Gatwick Airport Northern Runway Project

Statement of Common Ground Between Gatwick Airport Limited and Horsham District Council – Clean Version

VERSION: 3.0

DATE: AUGUST 2024

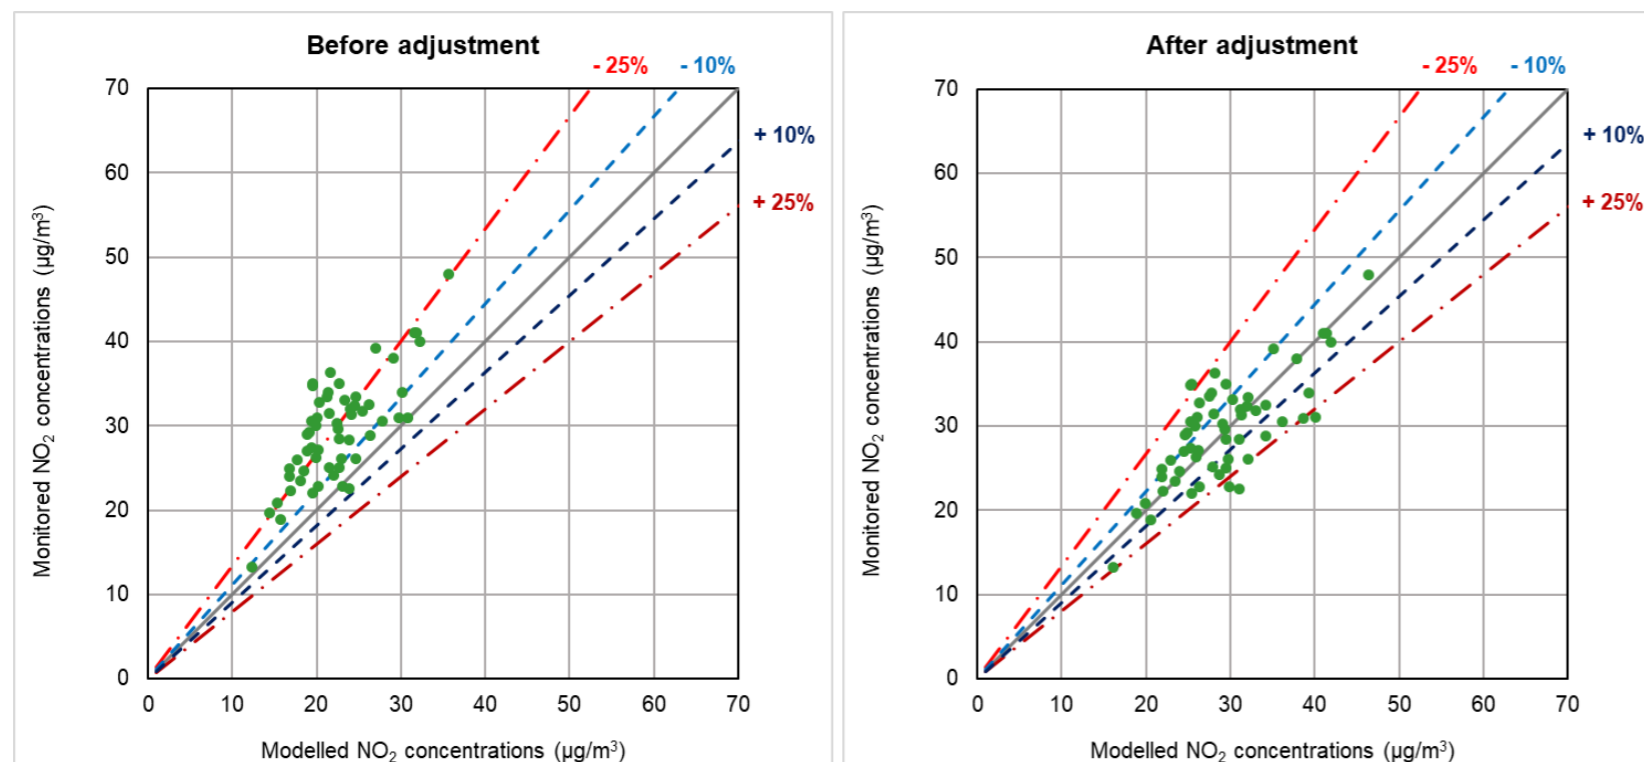
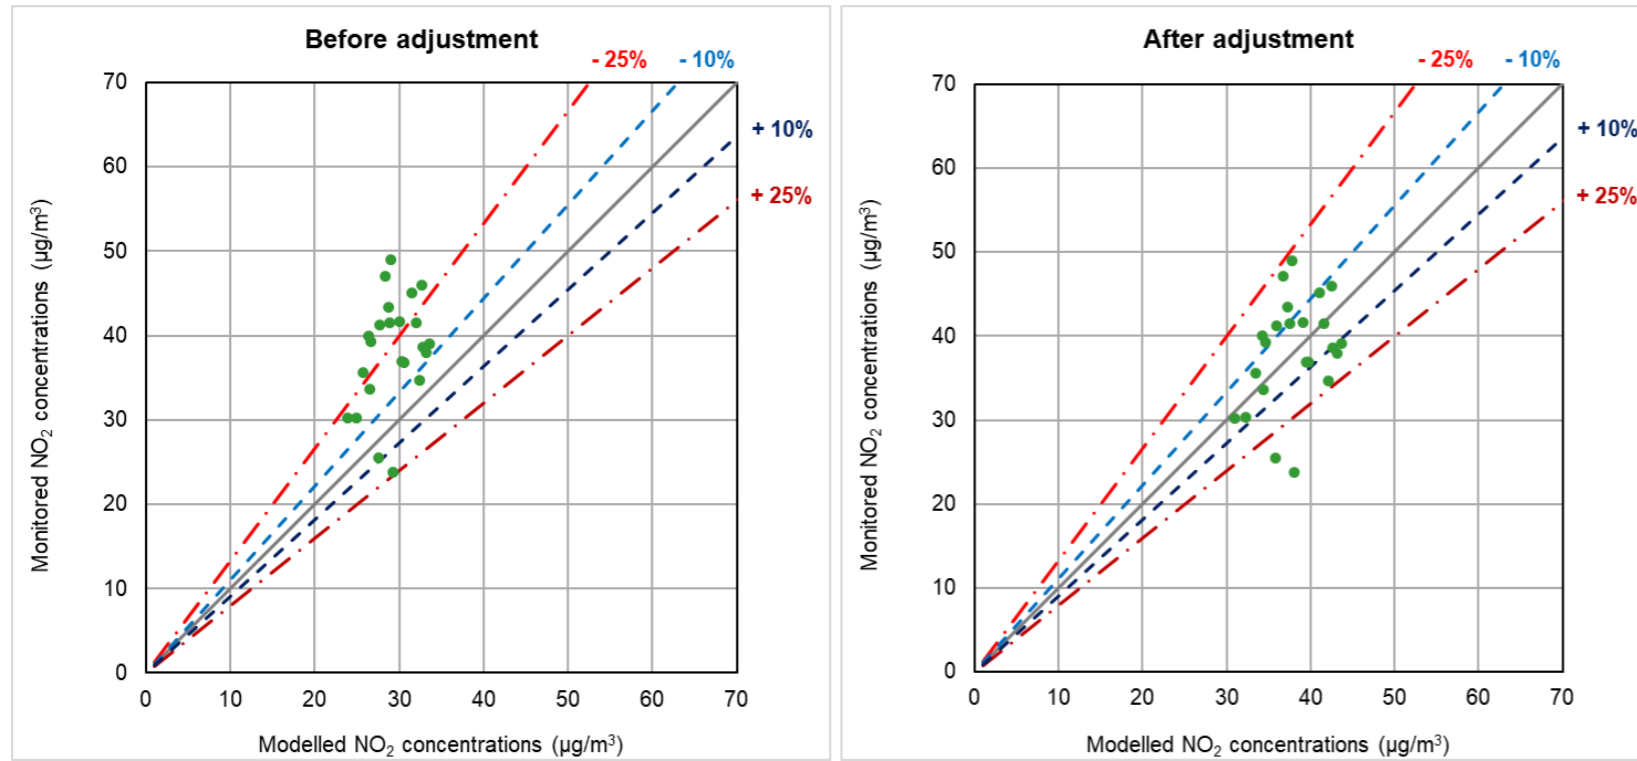
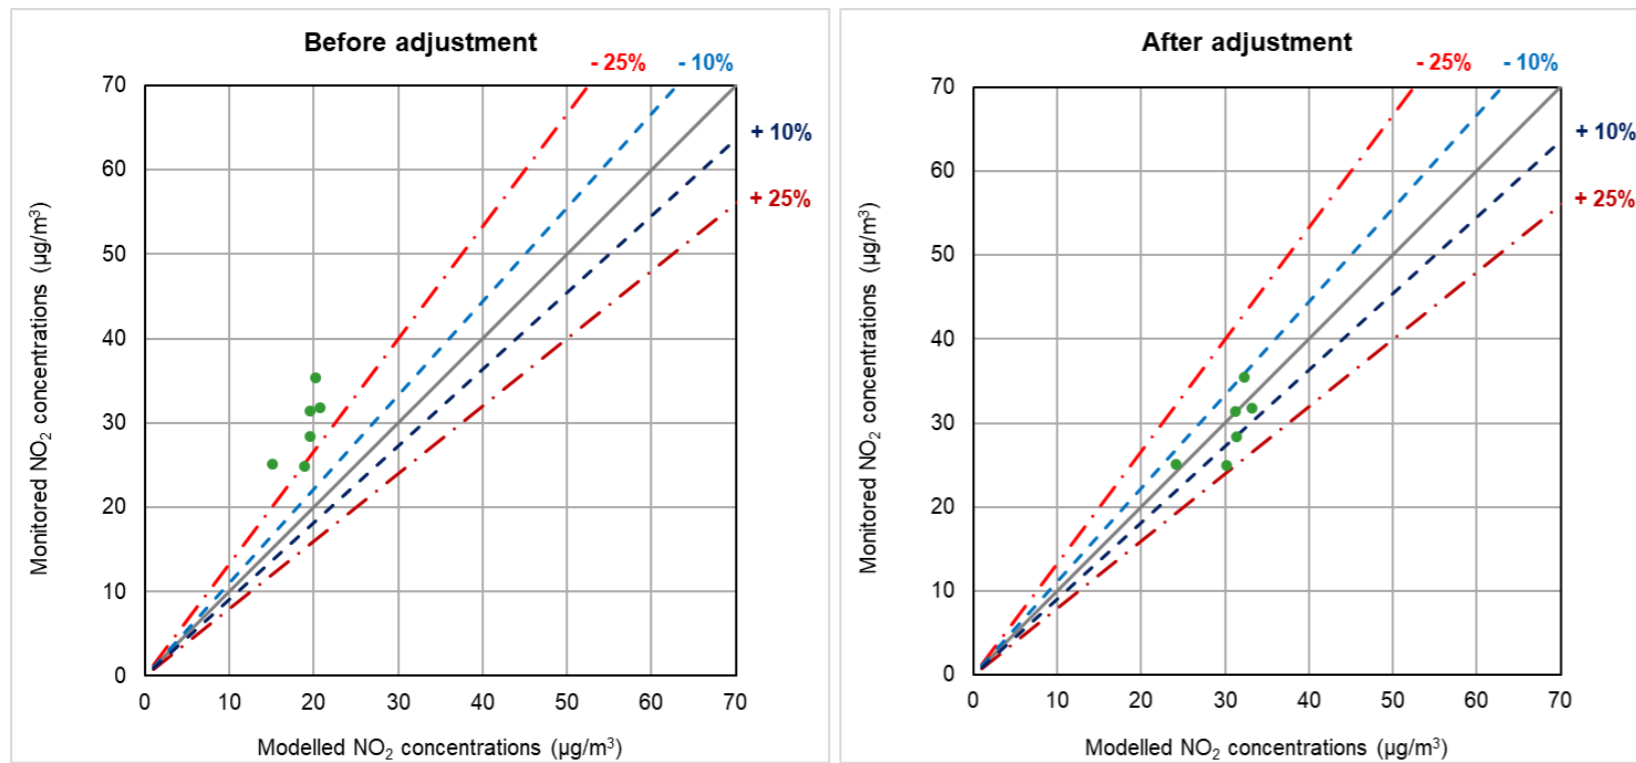
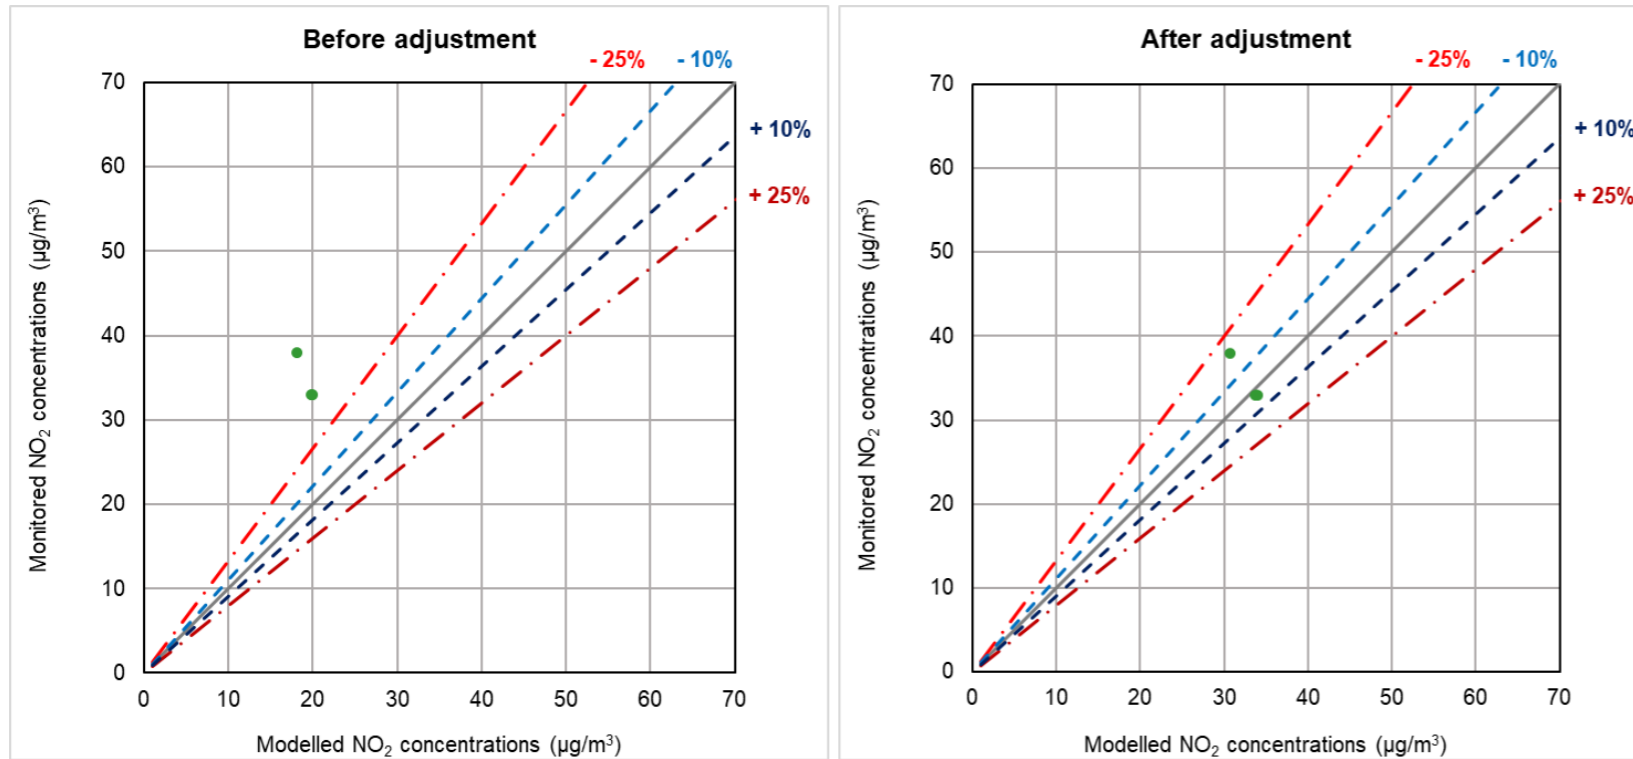
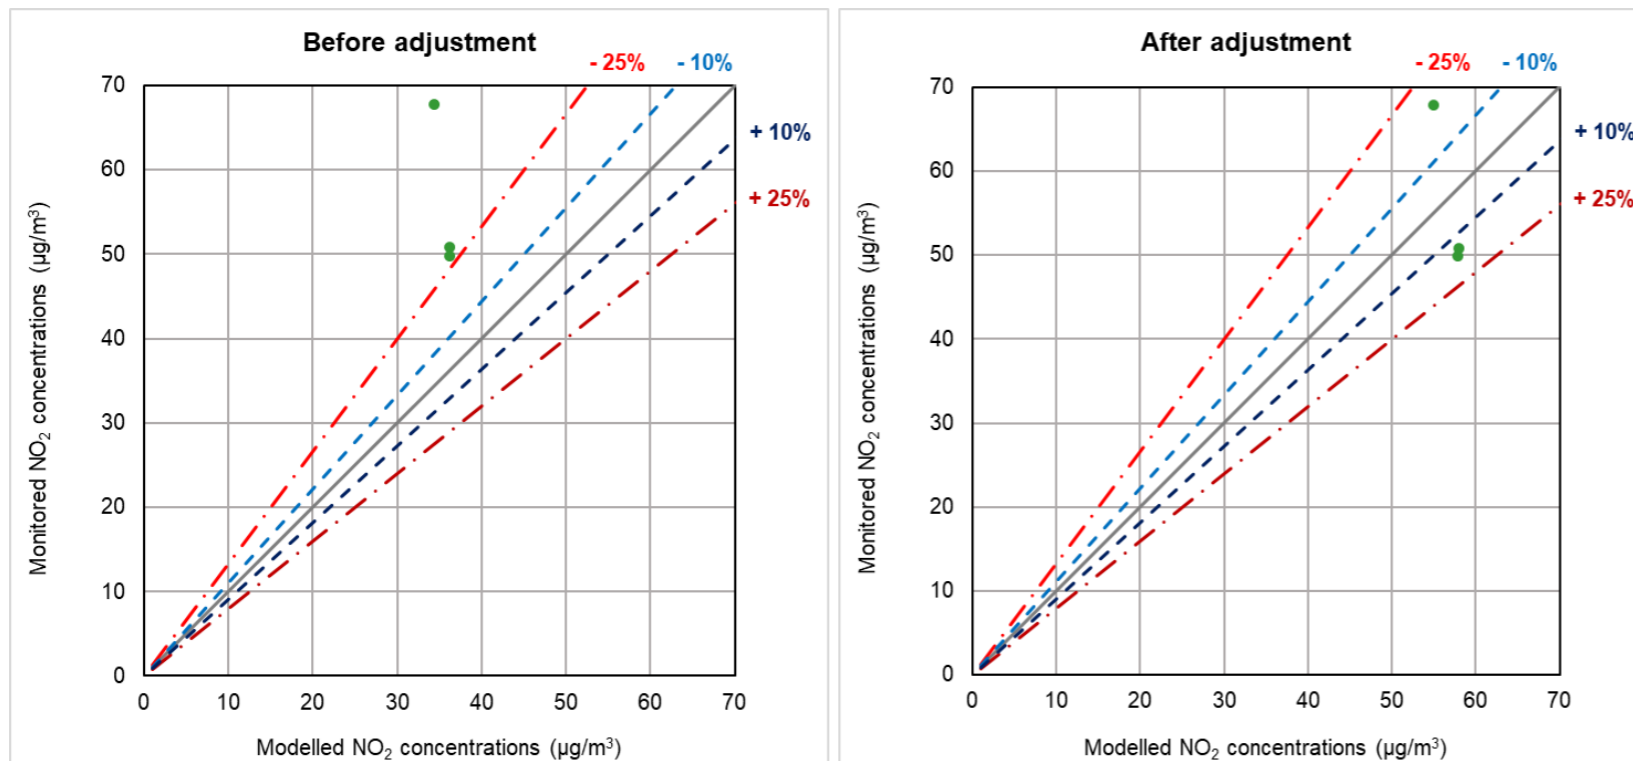
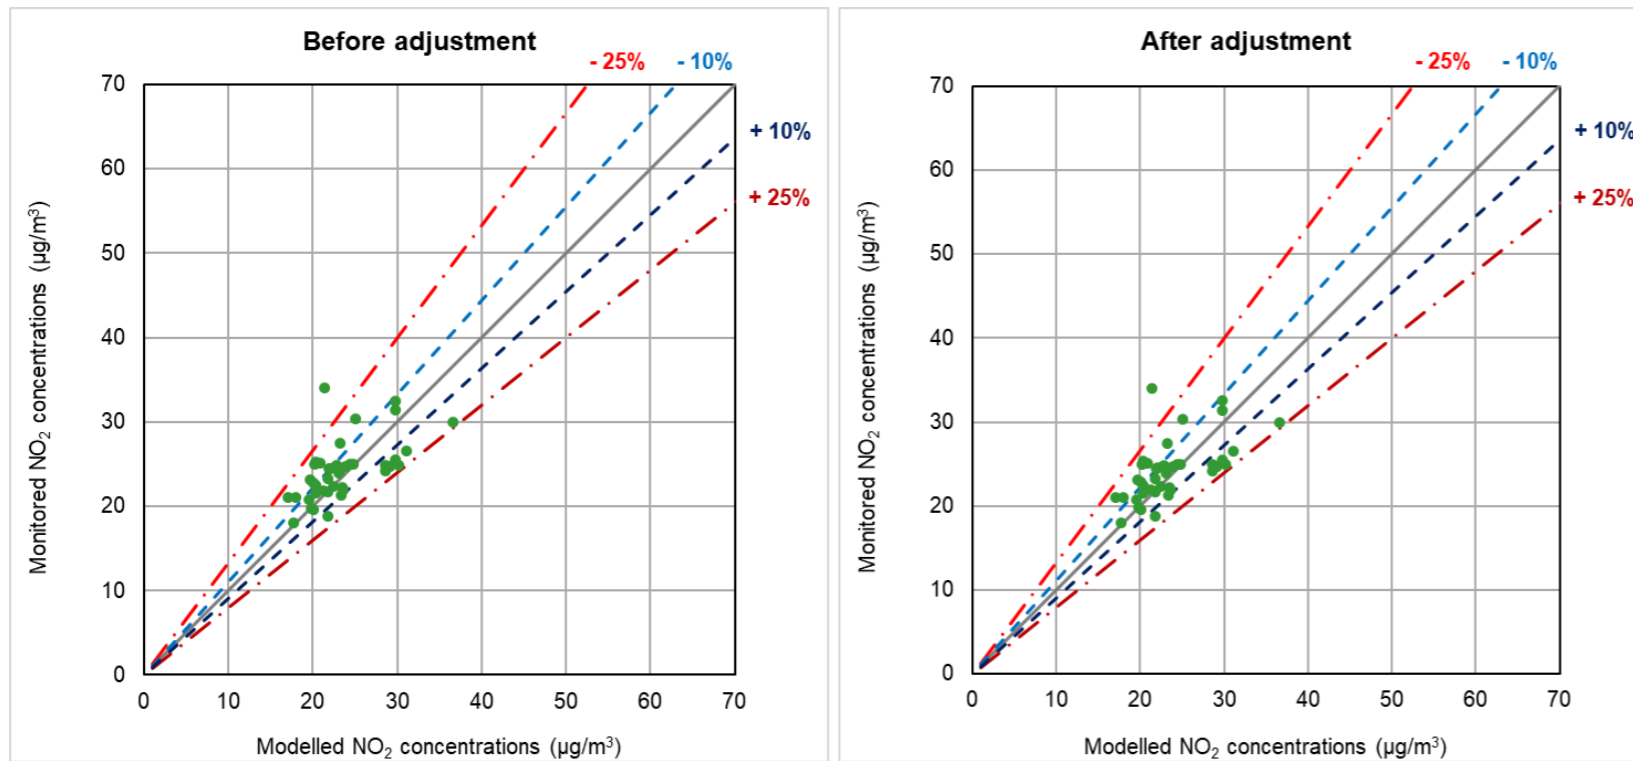
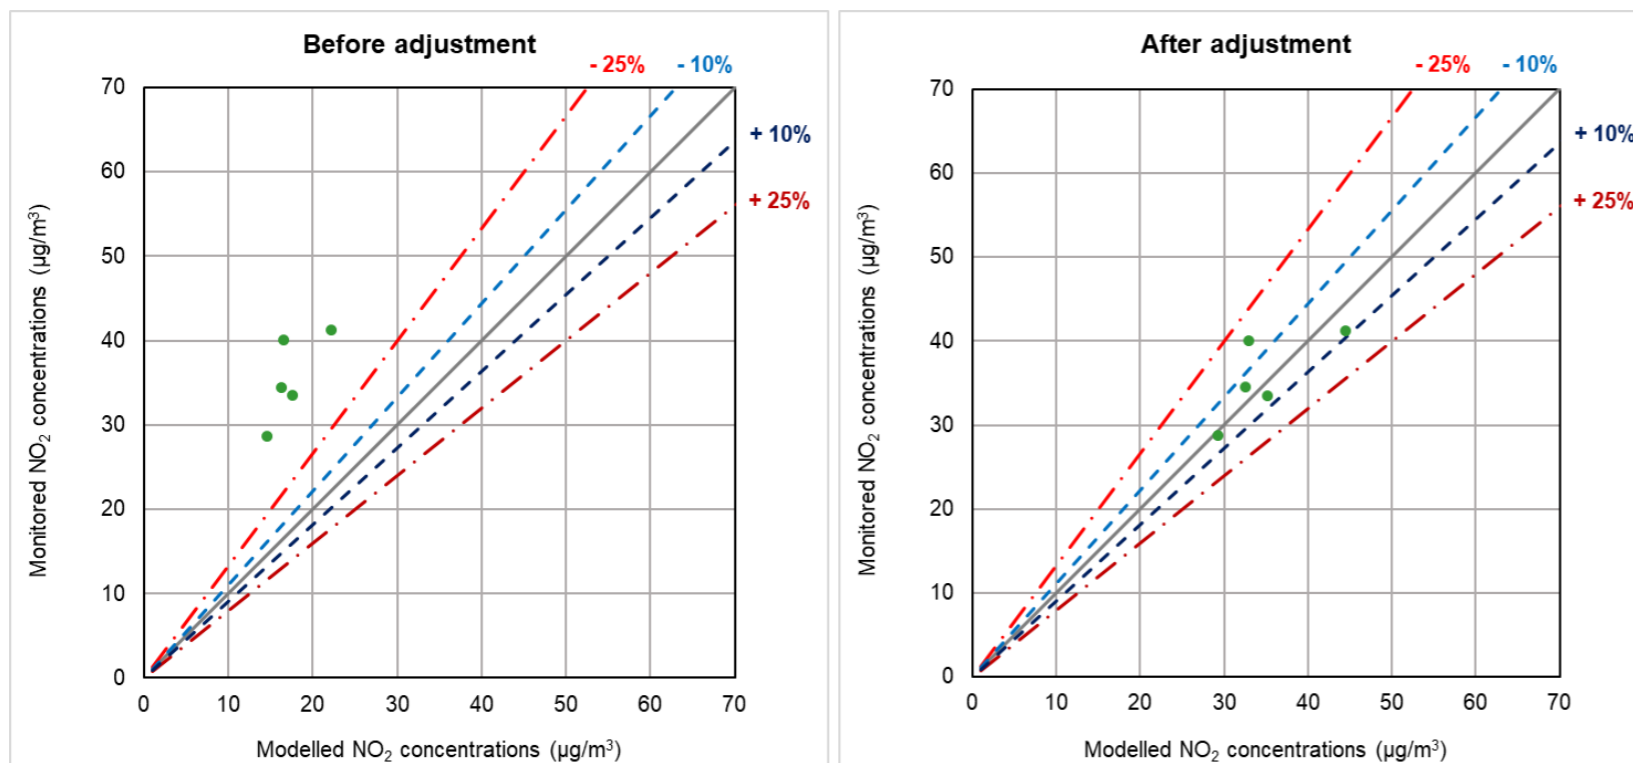
<p>2.2.2.3</p>	<p>Model Set Up and Methodology</p>	<p>Regarding model verification, Appendix 13.6.1: Air Quality Data and Model verification is missing details on how model verification factors for the selected zones were established. Details are required of the initial verification including Monitored Road NOx Contribution versus Unverified Modelled Road NOx, which monitoring sites were used, and which were removed from the verification process. To facilitate the scrutiny of the model set up and any assumptions used, it is requested that a complete set of input files be shared for 2018 (Base Year) and 2029 (nearest future year). In addition, Operational and Construction impacts for 2029 should be modelled jointly as one scenario, in order to enable the evaluation of all impacts associated with the development.</p> <p>Updated position (Deadline 1): We welcome the provision of model files. There are a few residual queries from this review and the review of the verification appendix. These include: further details on why so many sites were excluded from the verification and how we identify which receptors received which verification factor. Confirmation on why a later 2022 baseline year was not used too.</p> <p>It is welcomed that GAL propose to provide further information on modelling scenarios at the next air quality TWG. This matter will remain under discussion until this TWG has been held.</p> <p>Version 3 Deadline 5 Response Gatwick Airport Limited (GAL) sets of in paragraph 3.7.7 of their Response to Deadline 3 Submissions [REP4-031] that the air quality matters submitted by the Joint Local Authorities at Deadline 3 (Appendix A) [REP3-117] will be responded to by Deadline 5. This Appendix of air quality queries prepared by AECOM included a wide range of technical</p>	<p>Full details of the model verification process are included in Section 3 within the ES Appendix 13.6.1. Table 3.2.2 provides a list of all sites excluded along with justification and Table 3.3.2 provides a comparison between modelled and monitored NO_x and NO₂ concentrations.</p> <p>The verification methodology was agreed with local councils at the modelling methodology workshop in November 2022. Model files and results were provided to the TWG via email 18th August 2023.</p> <p>Traffic modelling has been undertaken for two construction scenarios, airfield construction and surface access (highways) construction. Further detail is contained in Report 7.4 of the Transport Assessment. The construction scenarios assume the peak construction traffic flows applied to the first year of airfield (2024) and surface access (2029) construction which is a conservative assumption since emissions and background concentrations are anticipated to improve in future years.</p> <p>As set out in paragraph 13.5.53 of ES Chapter 13: Air Quality, the 2029 surface access construction scenario represents years 2029-2032, during which there will be an overlap with the operation of the Project. The 2029 surface access construction scenario is a combined scenario considering the contribution from both construction and operational traffic over this period to represent a realistic worst case assessment.</p> <p>Updated position (Deadline 1): A verification figure has been provided at Deadline 1 which shows the factor applied to each</p>	<p>ES Appendix 13.6.1 Air quality Data and Model Verification [APP-159]</p> <p>ES Chapter 13 Air Quality [APP-038]</p> <p>ES Report 7.4 Transport Assessment [AS-079]</p> <p>Appendix A of the Supporting Air Quality Technical Notes to the SoCGs [REP1-050]</p> <p>Appendix D of the Supporting Air Quality Technical Notes to the SoCGs [REP1-050]</p> <p>Appendix A: Response to West Sussex Joint Local Authorities – Air Quality to The</p>	<p>Agreed</p>

<p>matters. Without a response from GAL further progress cannot be made. It is anticipated that further progress can be made before the next Examination Deadline.</p>	<p>receptor, contained in Appendix A of the Supporting Air Quality Technical Notes to the SoCGs (Doc Ref. 10.4).</p> <p>GAL has also set out the model scenarios and provide that summary at Deadline 1, within Appendix D of the Supporting Air Quality Technical Notes to the SoCGs (Doc Ref. 10.4).</p> <p>Updated position (April 2024): The Applicant notes that the JLAs have provided a submission on air quality at Deadline 3. The Applicant will review this submission and respond accordingly.</p> <p>Updated position (Deadline 5): The Applicant has provided a response to the air quality matter submitted by the JLAs at Appendix A: Response to West Sussex Joint Local Authorities – Air Quality to The Applicant’s Response to Deadline 4 Submissions (Doc Ref. 10.38). The Applicant will respond at Deadline 6 to the JLAs’ review submitted at Deadline 4 [REP4-053].</p> <p>Updated Position (July 2024): This matter can be marked as ‘agreed’ following consultation with AECOM on behalf of the local authorities on the technical queries set out at Deadline 5 [REP5-073].</p>	<p>Applicant’s Response to Deadline 4 Submissions [REP5-073]</p>
